EL PASO COUNTY PARKS DEPARTMENT | PARK PLANNING DIVISION

June 19, 2026

Subject: Rocky Mountain Chapel Filing No. 1 Final Plat (SF-25-008)

The Park Planning Division has performed a second review for the Rocky Mountain Chapel Filing No. 1 Final Plat development application of behalf of El Paso County Parks. This application was reviewed and brought before the Parks Advisory Board on April 9, 2026. The following comments for the second review are being provided administratively.

# RMCC ELLICOTT SUBDIVISION FILING NO. 1

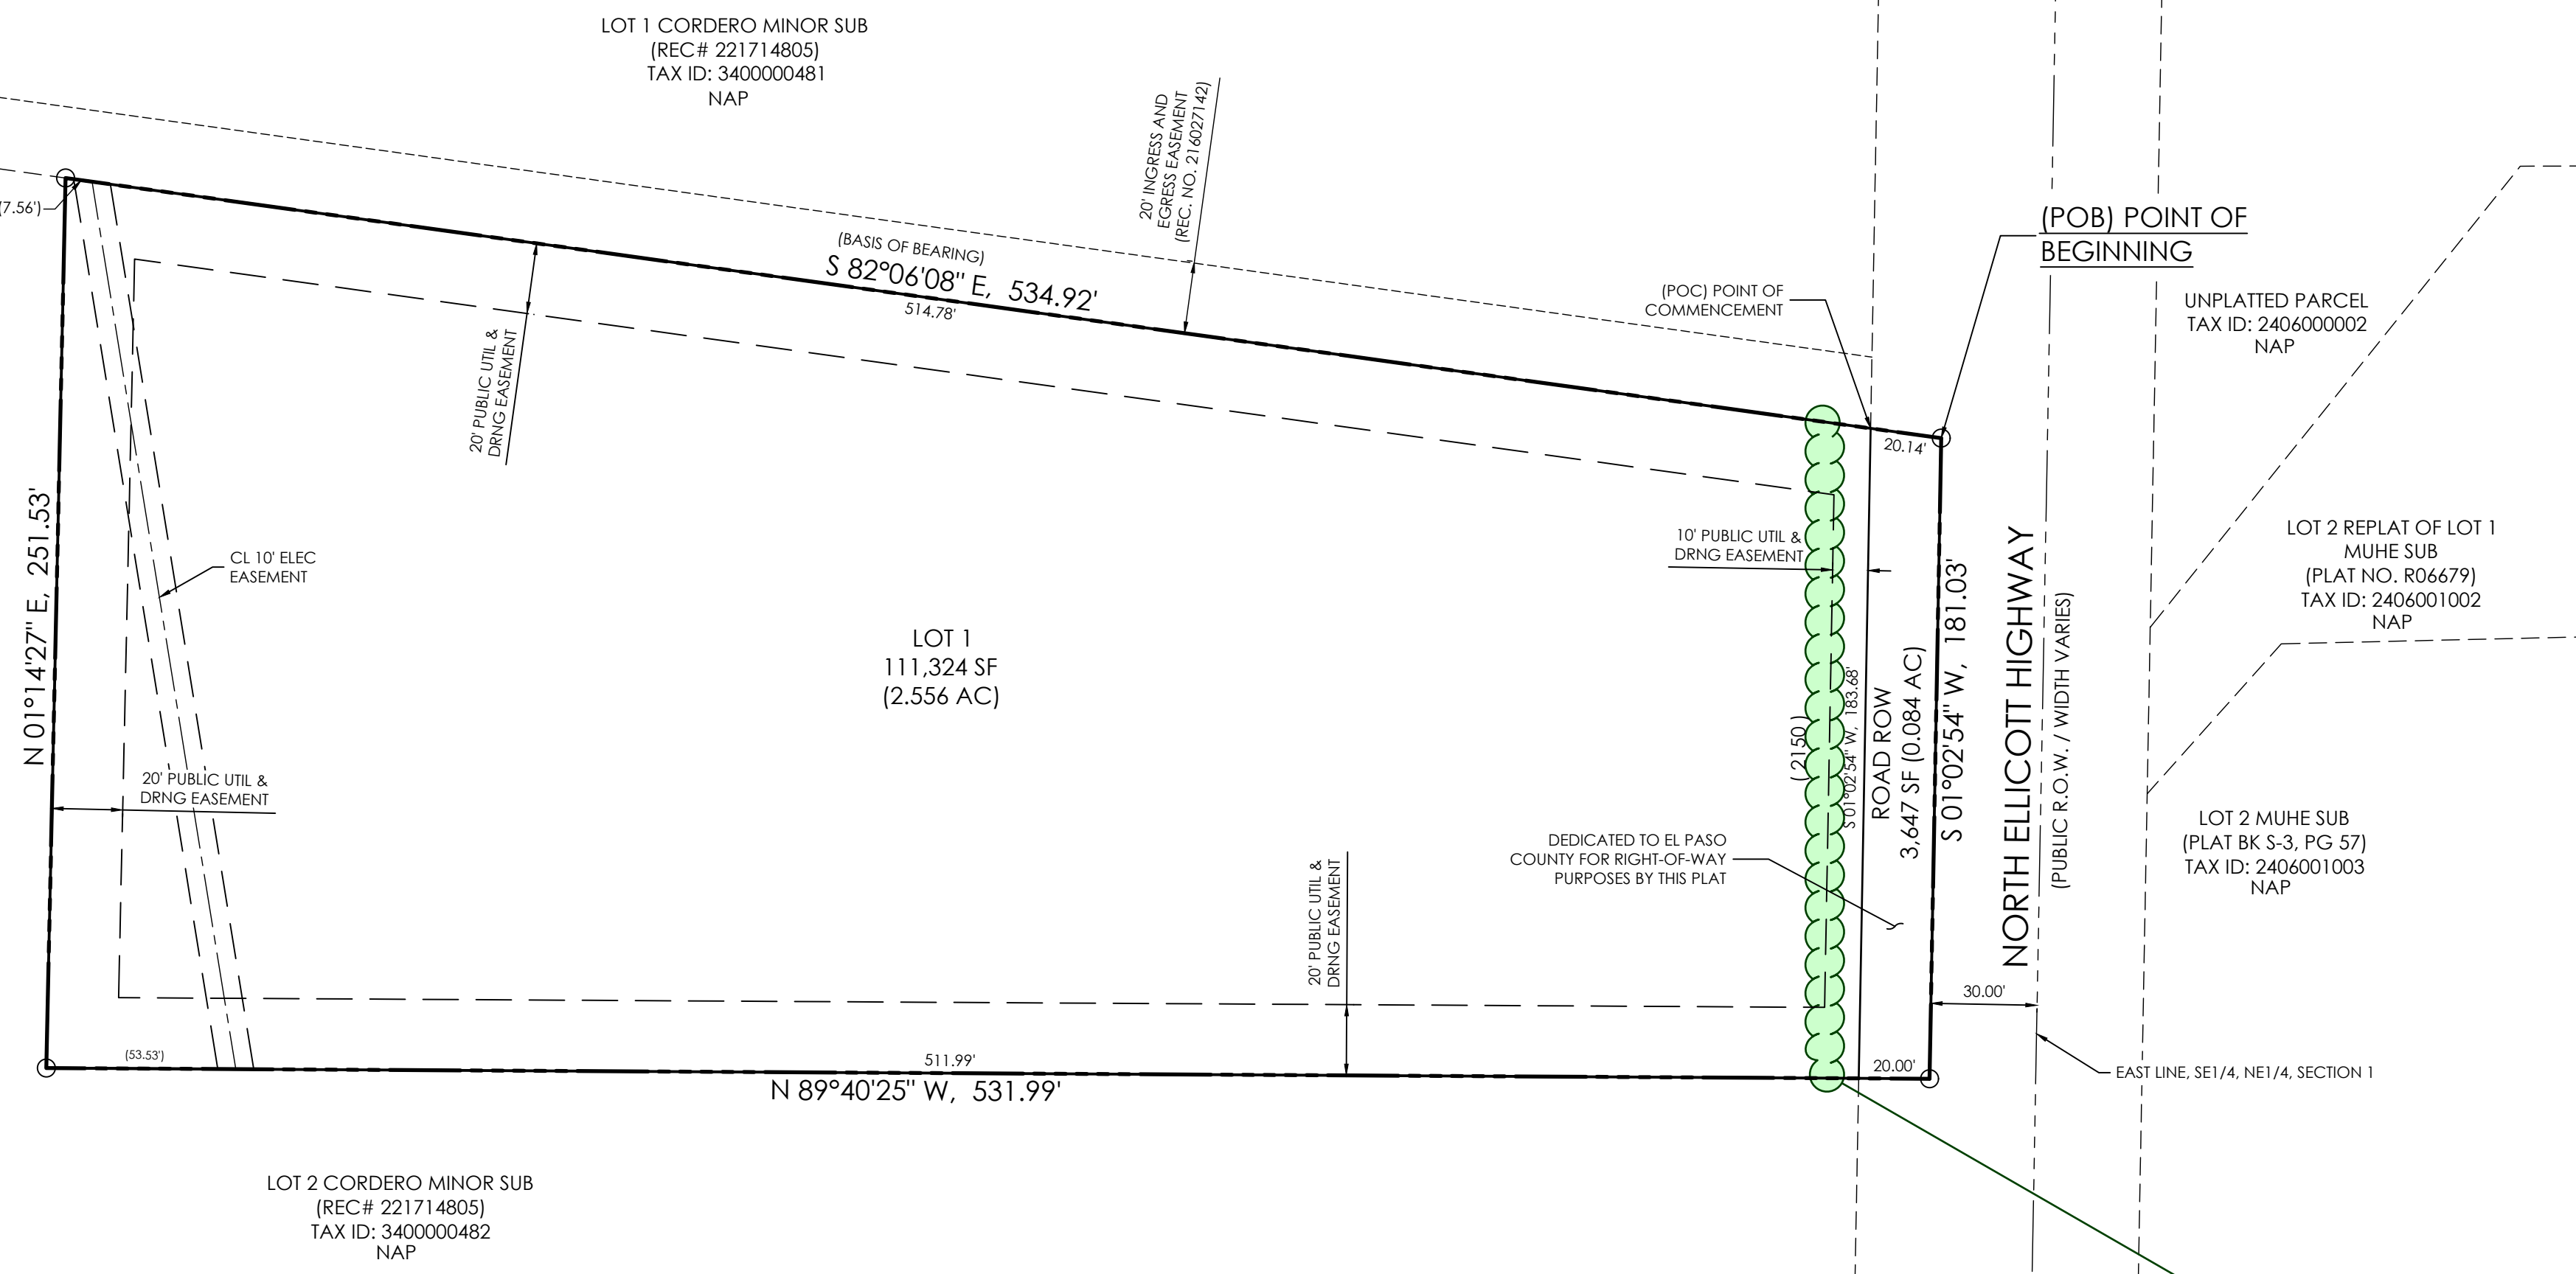
The 2022 El Paso County Parks Master Plan shows the project impacting the proposed Great Plains Primary Regional Trail corridor, which exists on the eastern property line, running north/south along North Ellicott Highway, as shown on the attached development application review map. The adjacent Cordero Minor Subdivision, which surrounds the subject property on all sides, dedicated a trail easement to El Paso County in August 2021. It should be noted that this impact is contrary to the following comments noted in the applicant's Letter of Intent:

County Parks requests trail easements where development projects impact proposed County trails. Upon the second review of the final plat staff noticed that trail easement was not depicted on the plat nor was a plat note provided. As it pertains to this application, the County requests that the landowner provide a 25-foot public trail easement along the west side of North Ellicott Highway, outside of the existing or proposed right-of-way, that

allows for public access, as well as construction and maintenance by El Paso County of the Great Plains Primary Regional Trail, and this easement shall be shown and dedicated to El Paso County on the Final Plat.

The Park Advisory Board endorses the following El Paso County Parks Department comments, recommendations, and requirements as they relate to Rocky Mountain Chapel Filing No. 1 Final: (1) require fees in lieu of land dedication for regional park purposes in the amount of \$505. (2) designate and provide to El Paso County a 25-foot public trail easement along the west side of North Ellicott Highway, outside of the existing or proposed right-of-way, that allows for public access, as well as construction and maintenance by El Paso County of the Great Plains Primary Regional Trail, and this easement shall be shown and dedicated to El Paso County on the Final Plat.
